From: [Mau, Russell E \(DOH\)](#)
To: [Zach Torrance-Smith](#)
Cc: [Melissa Schumaier](#)
Subject: RE: CU-25-00001 Hayford Well - Notice of Application
Date: Monday, January 27, 2025 3:56:27 PM

The Department of Health (DOH) Office of Drinking Water (ODW) has reviewed the application generating the following comments:

CDS is requesting comments on the following Conditional Use application: CU-25-00001
Hayford Well.

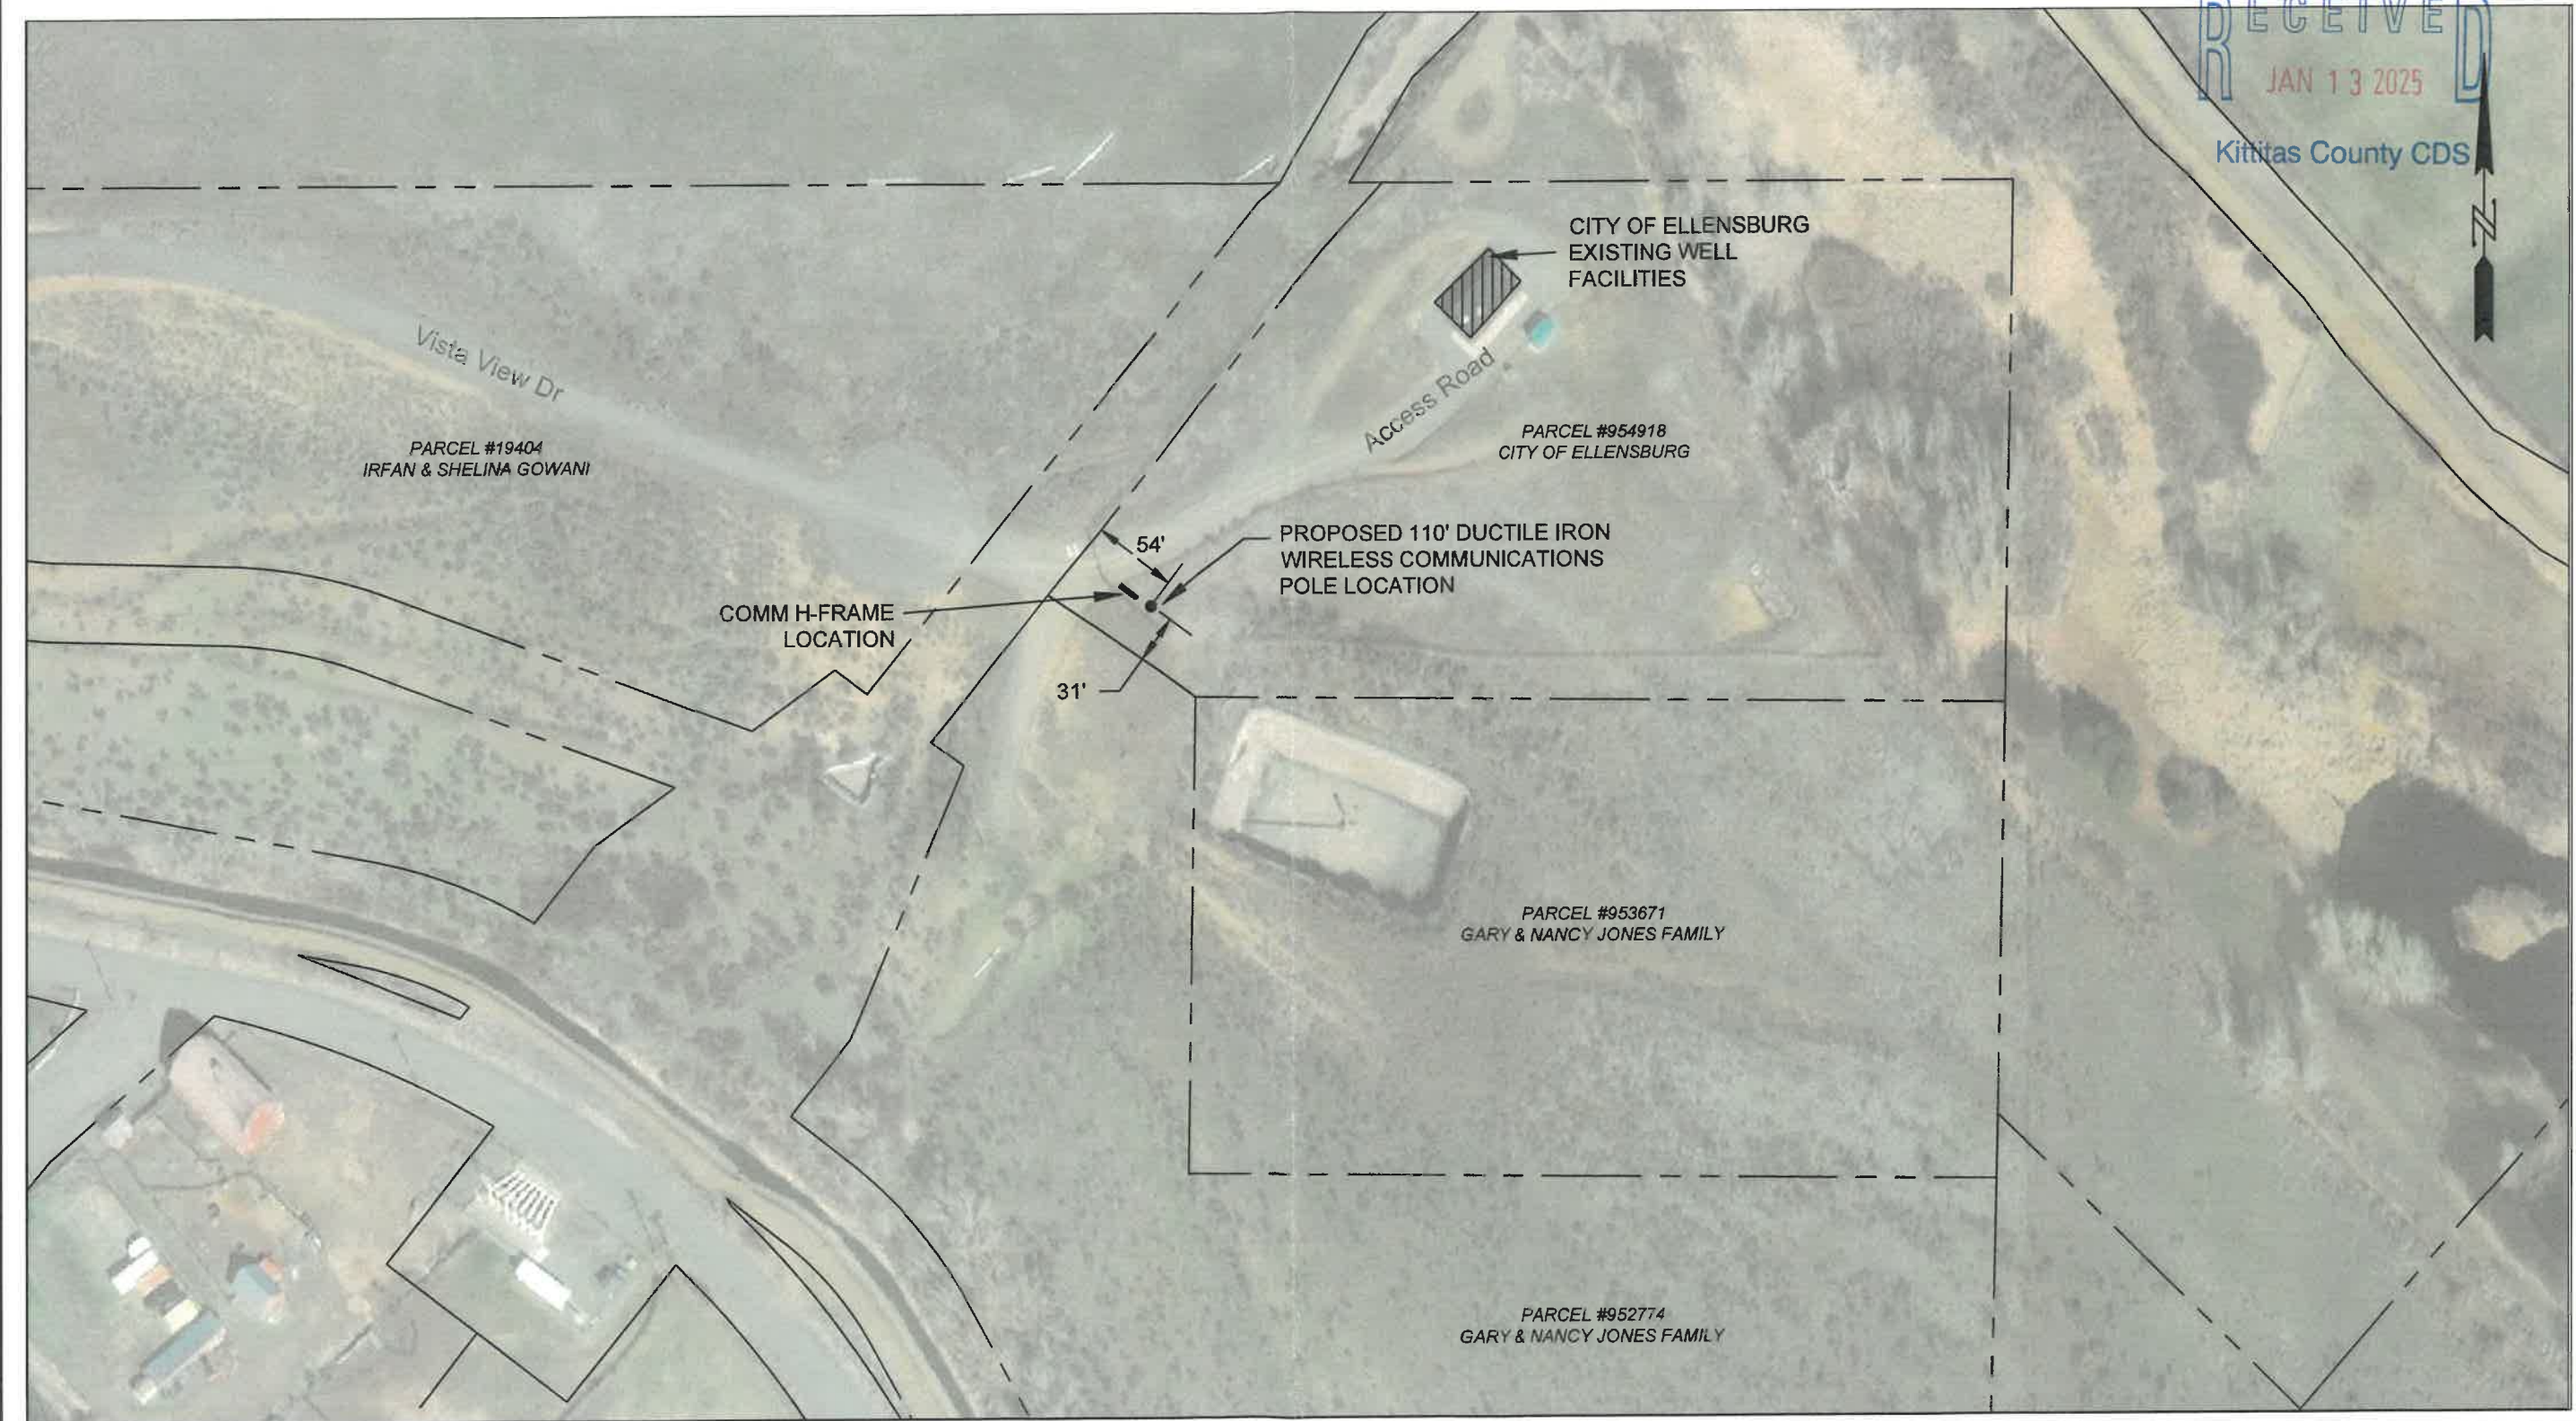
1. What is the pole's distance from the well?
2. How will service and maintenance vehicles access the pole, and where will they park?
